Response to Planning application from Hertfordshire County Council (T and CP GDP Order 2015)

District ref: 6/2017/0624/MAJ

Plot 5000 Hatfield Business Park

Erection of a 3 storey building for B8 (storage and distribution) (4,878 sq metres) and B1 (office/light industrial) (1,550 sq metres) use, together with 100 car parking spaces, 10 cycle parking spaces, boundary treatment, landscaping, lighting and access.

no  
**6050 - 087 Rev B**  
**PLANNING**

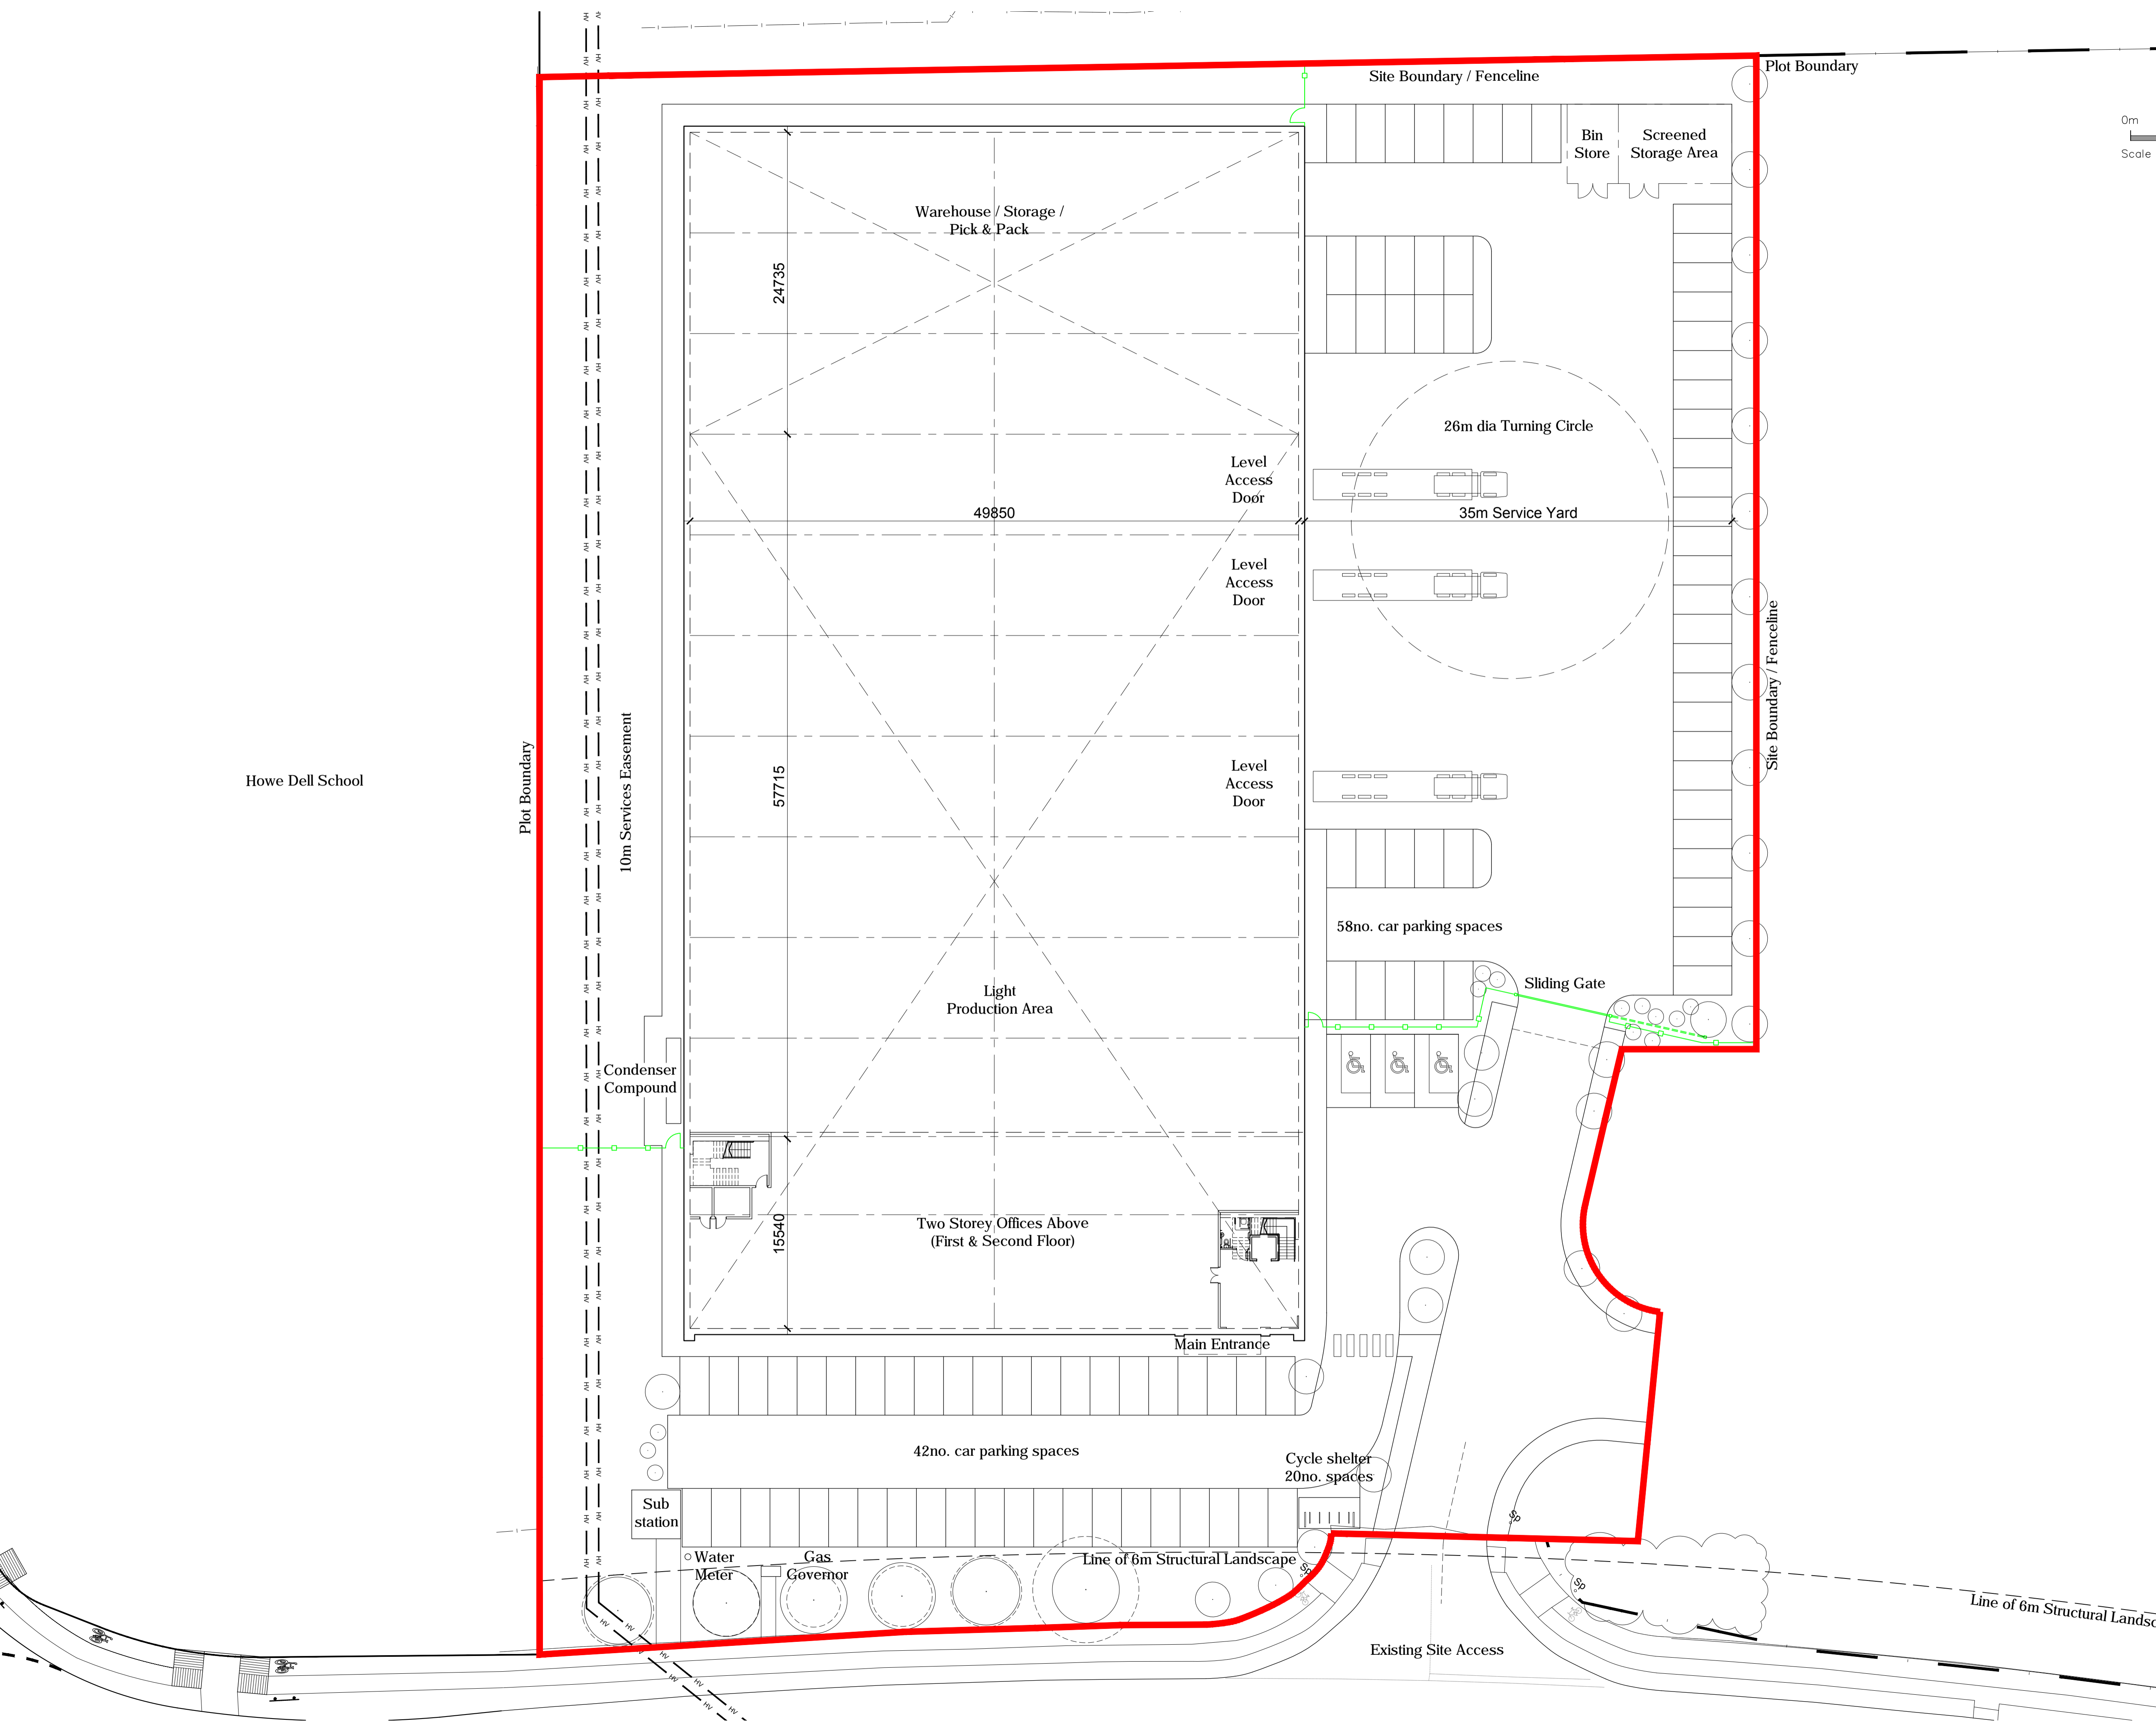
Drawing 6050 – 086 appears to incorrectly show road markings, suggesting that white centre hatching exists (variable length) either side of the access, however the existing layout provides right hand turn lane. Noting section 6 of the application form, it is considered that this detail on drawing 6050-086 is in error. It is recommended that the applicant be encouraged to correct this detail. Works on Mosquito Way shall not, presently, require Highway Authority approval, but loss of the marked right hand turn lane may interfere with the significantly progressed adoption process.

Parking is provided to the front, and rear (within the service yard) for a total of 100 car parking spaces. Service yard and rear parking is secured through use of sliding gate however this gate is set back sufficient from Mosquito Way that its' operation is not expected shall delay vehicles from accessing the site and shall ensure Mosquito Way remains unobstructed.

It is noted that site entrance also provides for future access to the remainder of Plot 5000 (eastern element) and HCC may require swept path details for future applications to be satisfied that the internal arrangements enable unimpeded access to adjacent uses. This may

Parking layout appears to be appropriate, in terms of bay dimension and clearances behind bays.

Space within the service yard would appear appropriate to enable articulated lorries to manoeuvre in order to load / unload at appropriate bays, and to leave the site in forward gear. Separately, the occupier shall need to consider the interaction of pedestrians and vehicles within this operational area, however that is governed by separate UK legislation.

Landscaping is sufficiently set back that it shall not interfere with visibility from the access, and although S38 adoption procedures are continuing it would not appear that the proposed planting shall interfere with agreed details.

The proposals do not represent any greater impact than considered within the original outline consent for the site. The proposals shall not result in any greater levels of trips generated by the site, either across the day, or within the peaks. The local highway infrastructure, and other mitigation and improvements, secured through the outline consent are sufficient to deal with the impacts of the proposal, with no additional impact expected associated with the proposals. Proposal is acceptable in terms of the impact on local highway conditions. Site layout and access appear acceptable, however it is observed that the highway Authority would not support introduction of centre lane hatching on approach to site access.
